Our Case Number: ABP-316272-23

Re: Bus Connects Templeogue/Rathfarnham to City Centre Core Bus Corridor Scheme
Templeogue/Rathfarnham to City Centre

**SUBMISSION/OBSERVATION ON TEMPLEOGUE / RATHFARNHAM TO CITY CENTRE CORE BUS
CORRIDOR SCHEME DUBLIN**

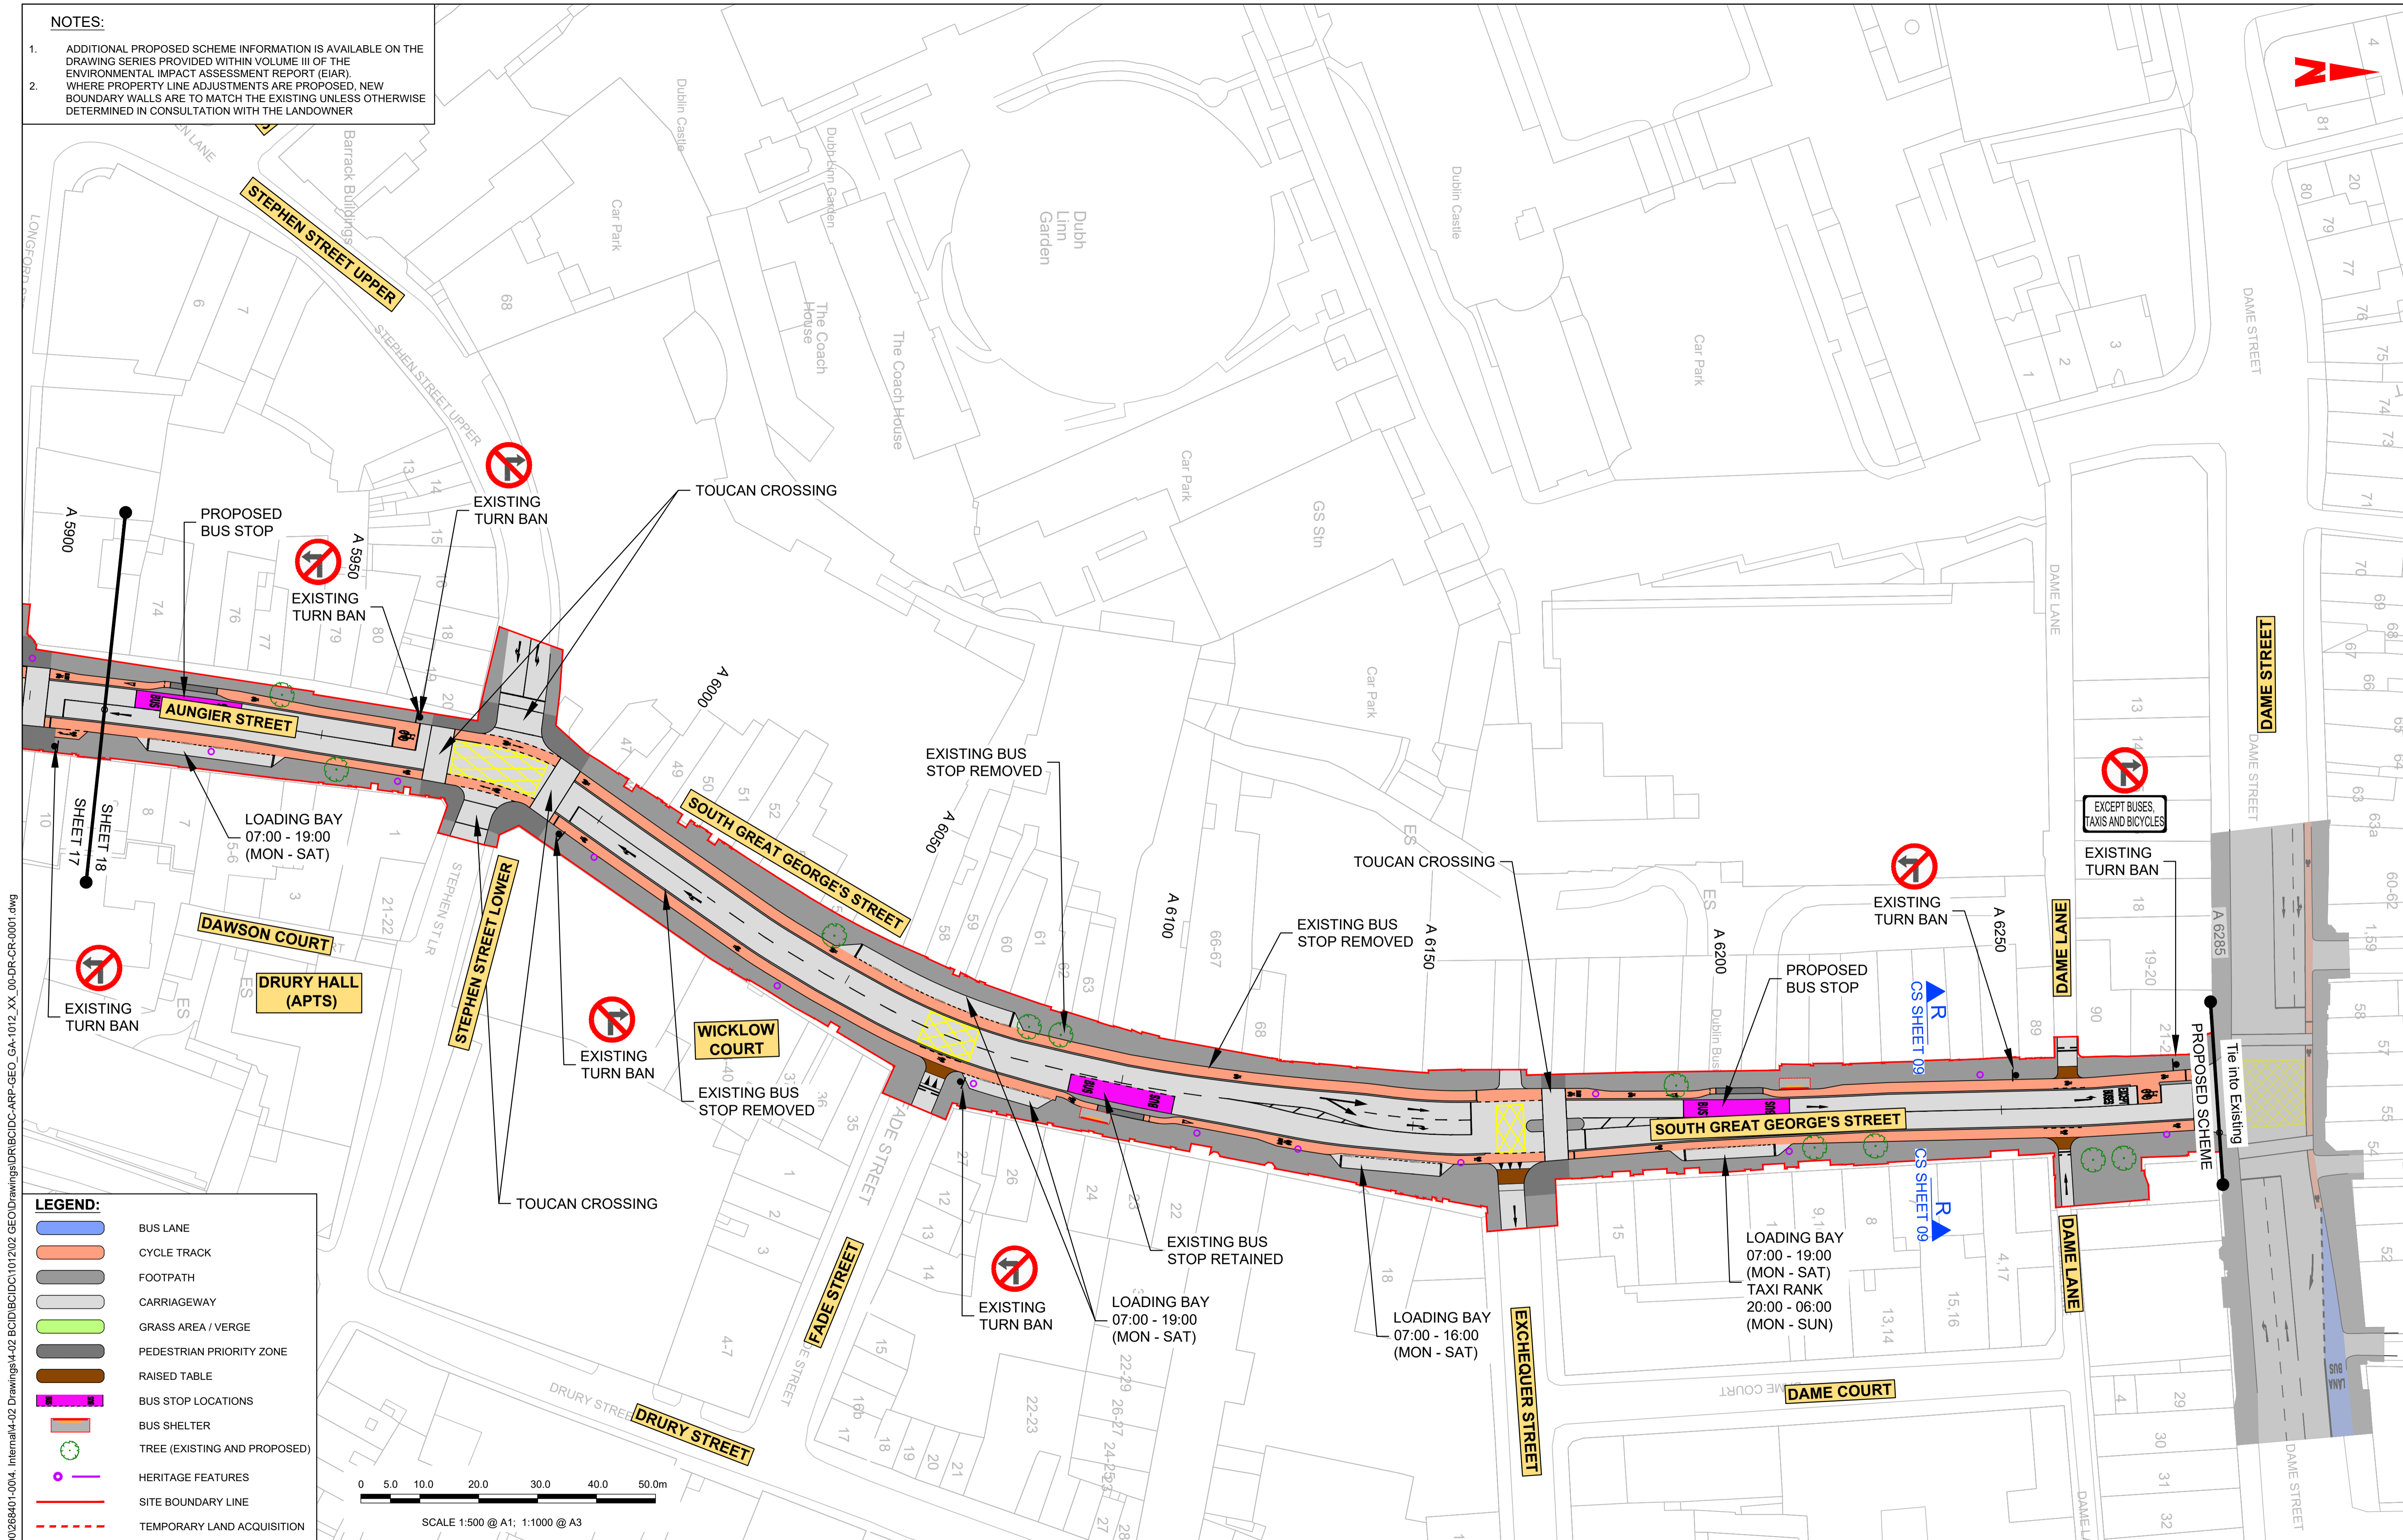
The current proposal of the Templeogue / Rathfarnham to city centre core bus corridor scheme at the junction of Terenure Road East and Brighton Road shows a raised table at the southern entrance to Brighton Road. No further mitigation measures are being proposed.

Image 3.1: Extract of the Templeogue / Rathfarnham to city centre core bus corridor scheme General Arrangement Drawings, Sheet 07 of 42, April 2023

Despite recent reduction in speed limit from 50km/h to 30km/h, anecdotal evidence shows high speed rat running on a daily base by vehicles trying to avoid driving through Terenure Village / Rathgar Village by using Brighton Road or Brighton Road + Harrison Row as a bypass with a significant danger to the vulnerable road users and residents on the street as a result. As the transport modelling as part of this application shows, the traffic is expected to intensify down Brighton Road while no mitigation measures are proposed, further increasing the danger to residents and visitors of the child care facilities and church on the street. Brighton Road is designated as a Local Road and as such should be designed to passively calm traffic through the creation of a self-regulating street environment that are suited to all users, including pedestrians and cyclists in line with Design Manual for Urban Roads and Streets (DMURS). To date Brighton Road fails to do live up to this standard, and the (lack of) proposed changes to the road layout as part of this application appear to worsen the situation.

As part of the road works associated with the the proposed bus corridor scheme, traffic calming measures should be introduced along the length of Brighton Road to reduce the speed of vehicles driving through and discourage the use of Brighton Road as a short cut and avoid 'rat running'.
